# City of Albuquerque Stormwater Construction Site Inspection Report

Project Name and Location	BHI Parking Lot Jefferson and Mesquite		
Site Contact Name & Agency	Bruce Sidworthy BHI	Contact Phone #	923-1000
Date of Inspection	6-28-16	Start/End Time	9:00/9:10
Inspector Name, COA Dept.	Curtis Cherne, Stormwater Quality		
Inspector Phone / E-mail	505-924-3420/ccherne@cabq.gov		
Inspector Qualifications	Qualified Compliance Inspector of Stormwater- Stormwater One		
Describe Present Phase of Construction	Stabilize

**From:** Cherne, Curtis  
**Sent:** Friday, June 10, 2016 1:49 PM  
**To:** 'Bruce Stidworthy'  
**Cc:** 'grant@inspectionsplusinc.com'  
**Subject:** BHI parking Lot SWPPP inspection  
**Attachments:** cement\_pollution.jpg; north\_inlet.jpg; SW\_Inlet.jpg; phasing.jpg

Project Title Bohannon Huston Parking Lot Repaving Project

**Bohannon Huston
Parking Lot Repaving Project**

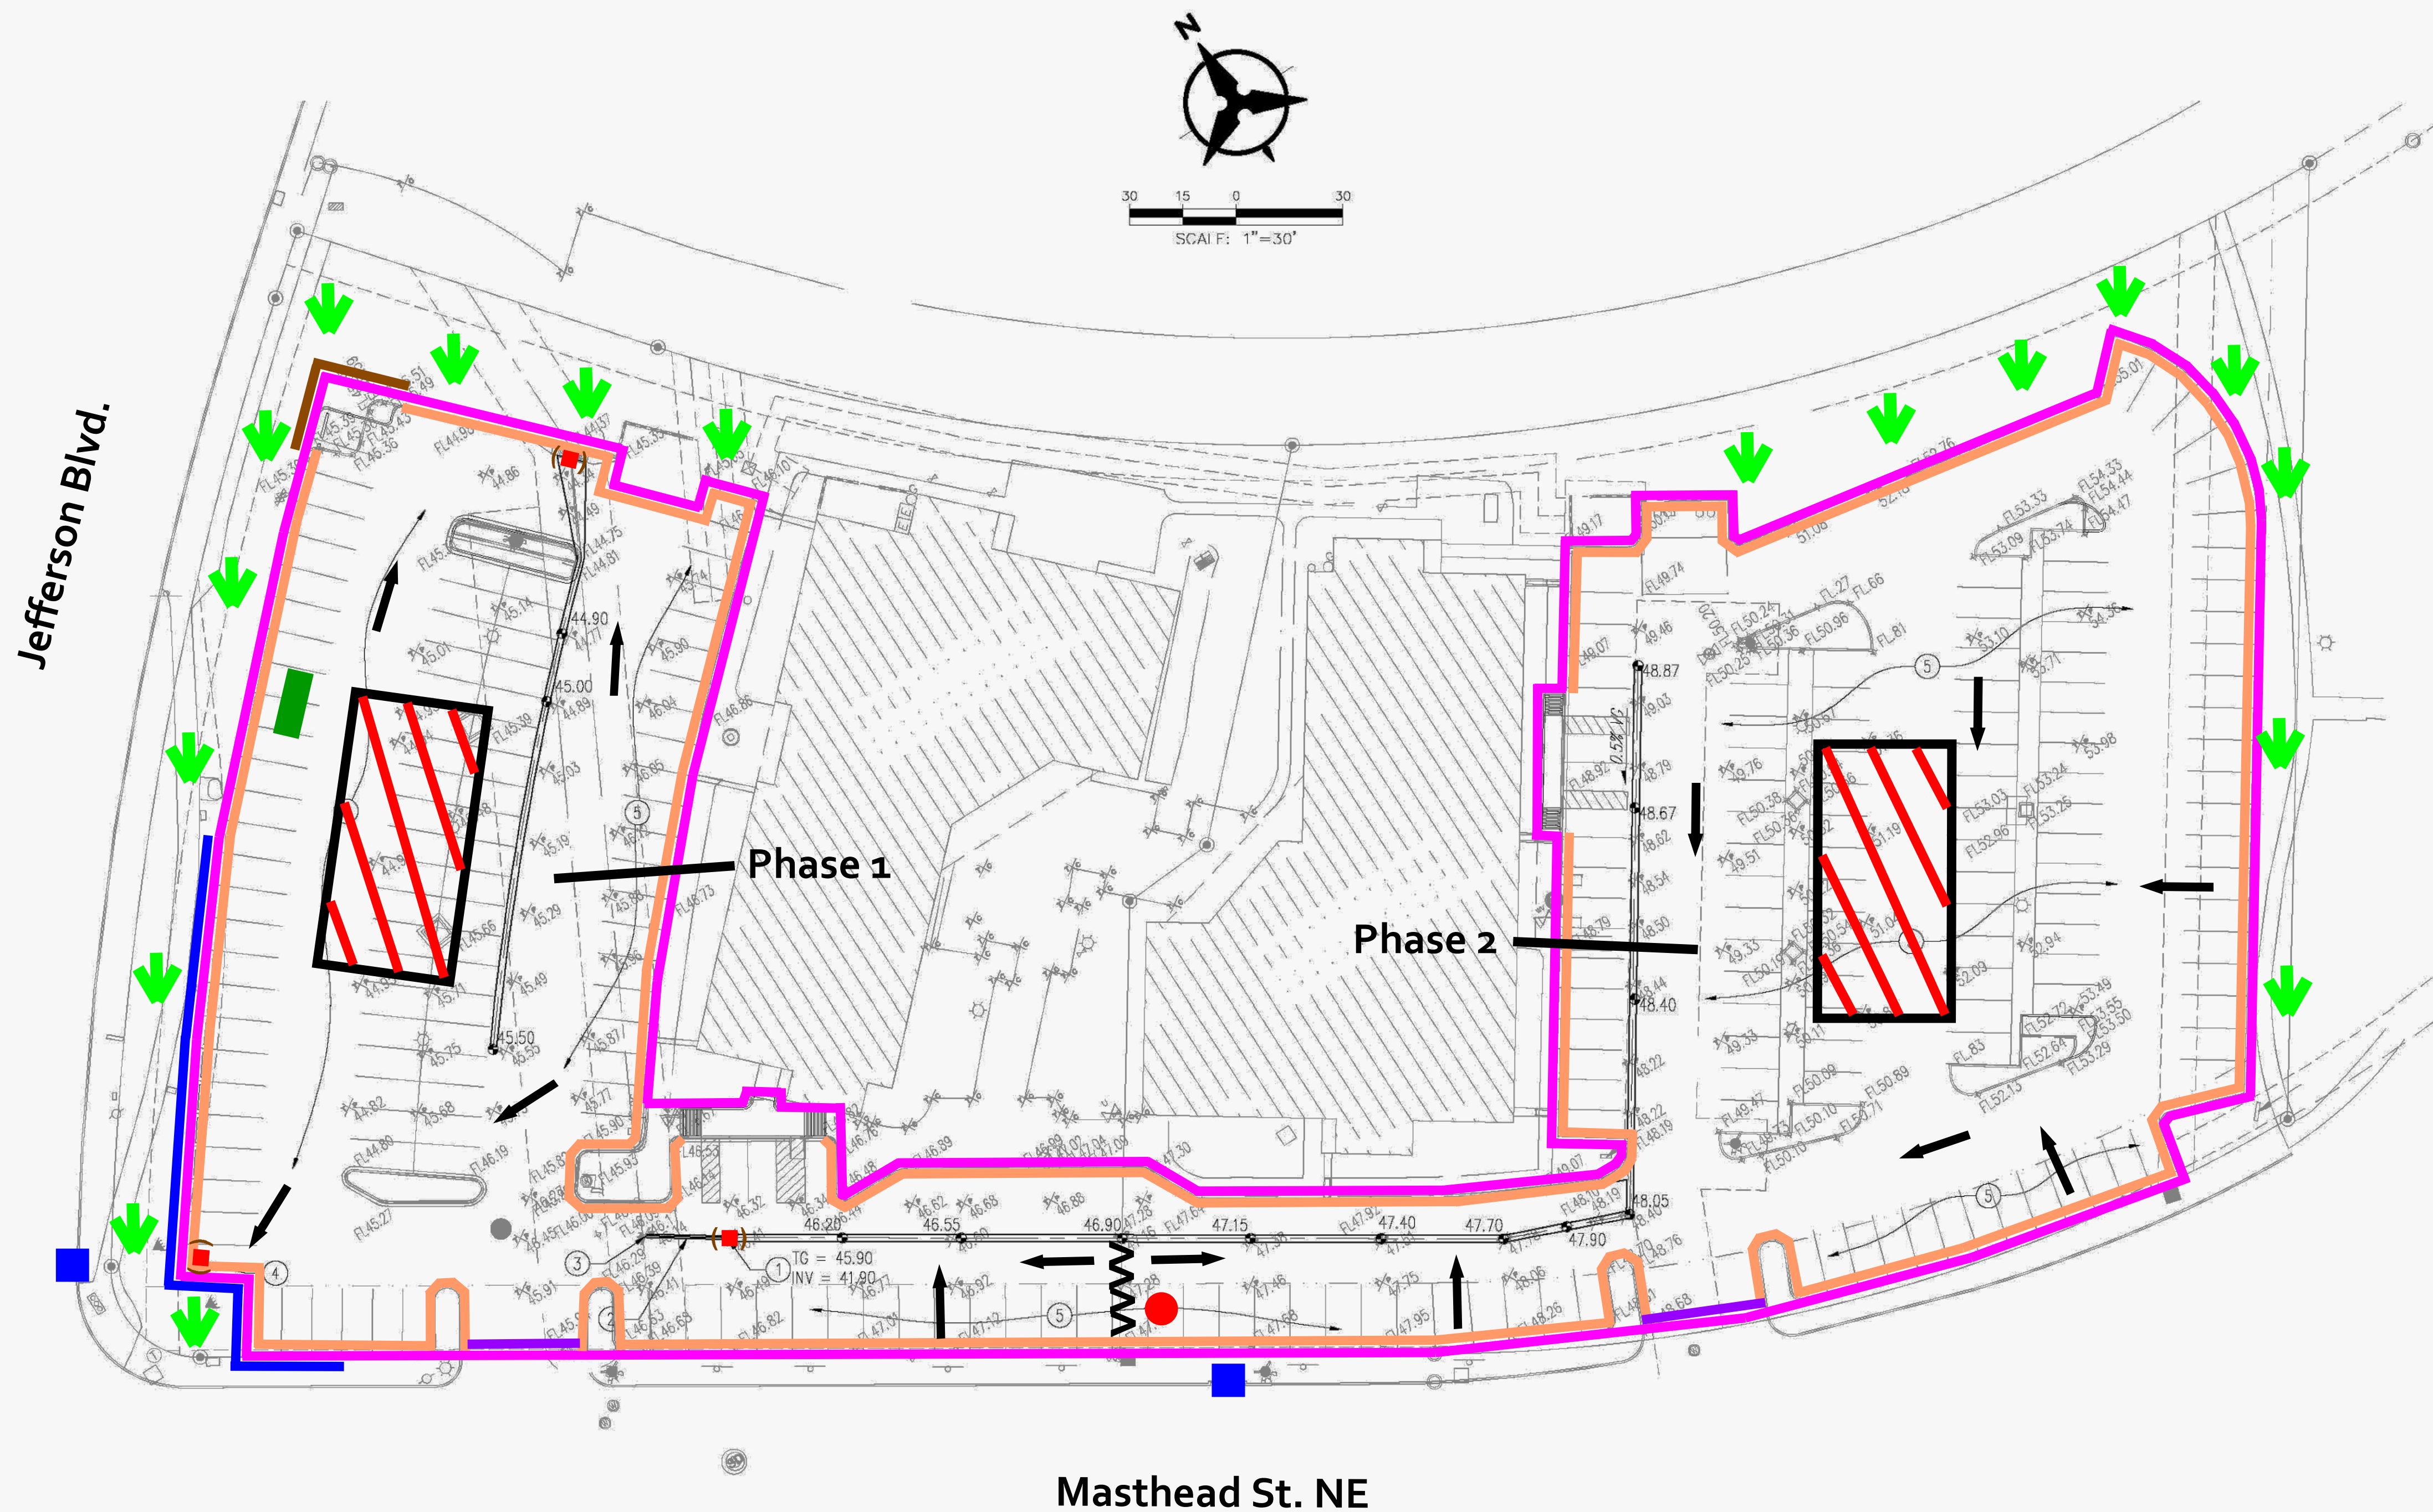
I've reviewed the plan and have a question concerning no track-out pad.

During Phase 1 the contractor(s) can drive through Phase 2. It seems like a long enough distance to effectively work for track-out.

However, I don't see how it will work during Phase 2. BHI will not want the contractor to drive on the new asphalt. I saw the note that it will be swept each day. I like that. However, if the dirt gets wet, the track-out could get away from them without a track-out pad.

Please justify why you feel a track-out pad should not be in place for Phase 2.

This project will be done in 30 days. The contractor will use the phase 1 parking lot to enter Phase 2 because once the asphalt is demo'd they are grading and right back with base course so the trackout would interfere with construction on both phases. Hence the street sweeping to manage trackout
